HOTHERSALL PARISH COUNCIL

28th August 2012

Planning Application 3/2012/0157 – New multi-purpose agricultural building on land adjacent to Hothersall Lane

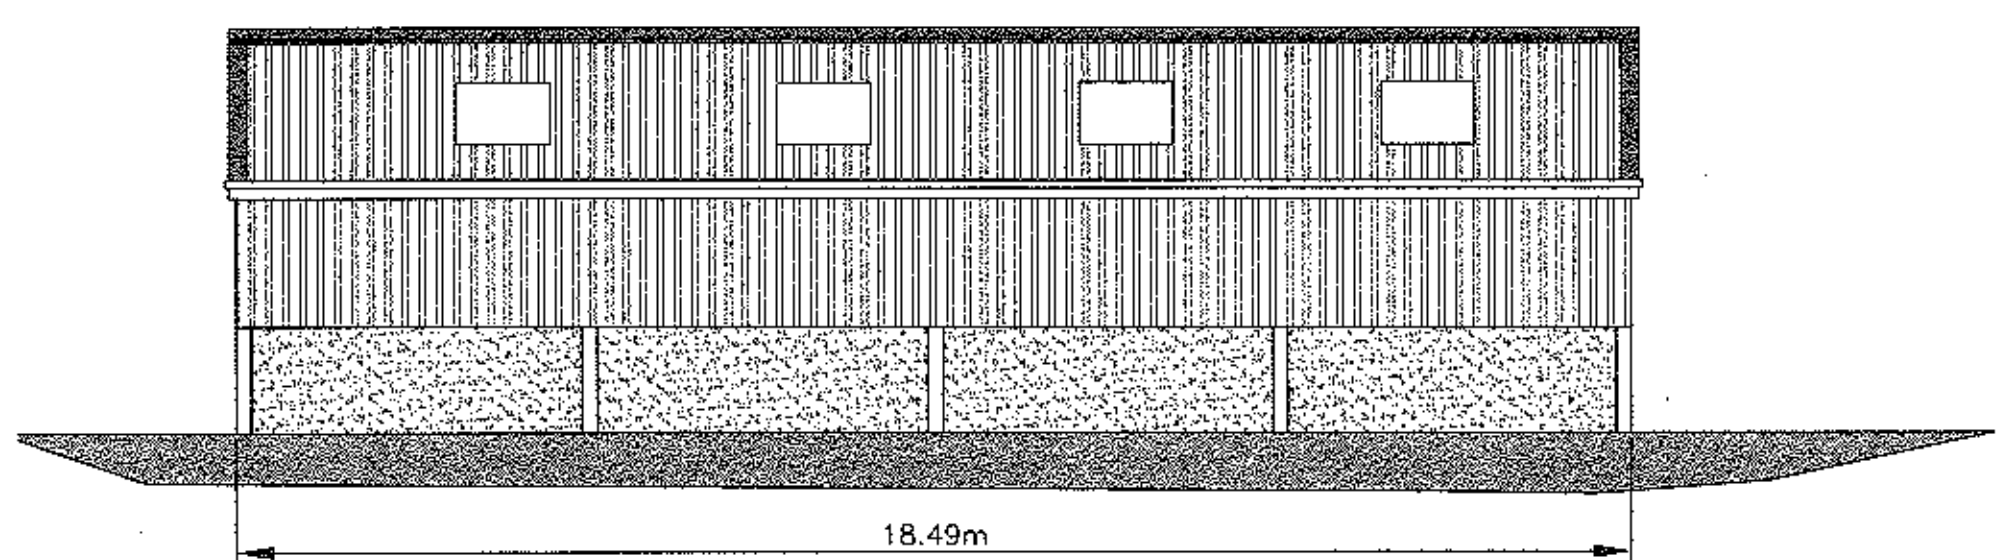
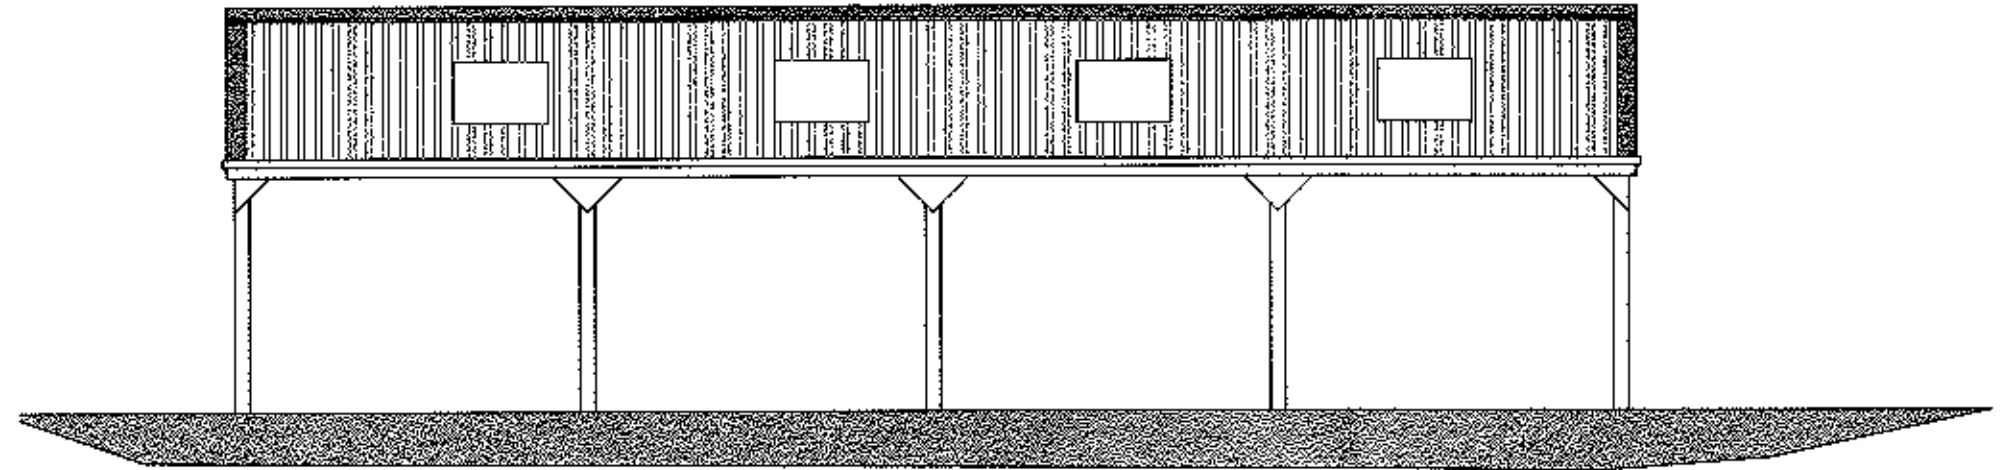
1. The imprecise nature of the plans. It remains impossible to determine where exactly this building will be placed in relation to the roadside hedge. The suggestion is that it will be rather close.
2. Visual Impact. This is a large building which will be partially screened by the roadside hedge but the upper sections will be highly visible and they will severely detract from the visual amenity of our pleasant country lane.
3. The new building is not part of an existing farm complex. Granting permission will create a precedent for future planned expansion at this site and even ribbon development down Hothersall Lane.

- (b) Provisions for the disposal of waste given the closeness of the building to a nearby ditch
- (c) The materials used for construction. The upper portions of the building will be highly visible above hedge level. It might be considered that they would blend in better with the landscape if they were constructed in dark green material rather than the bare wood envisaged.
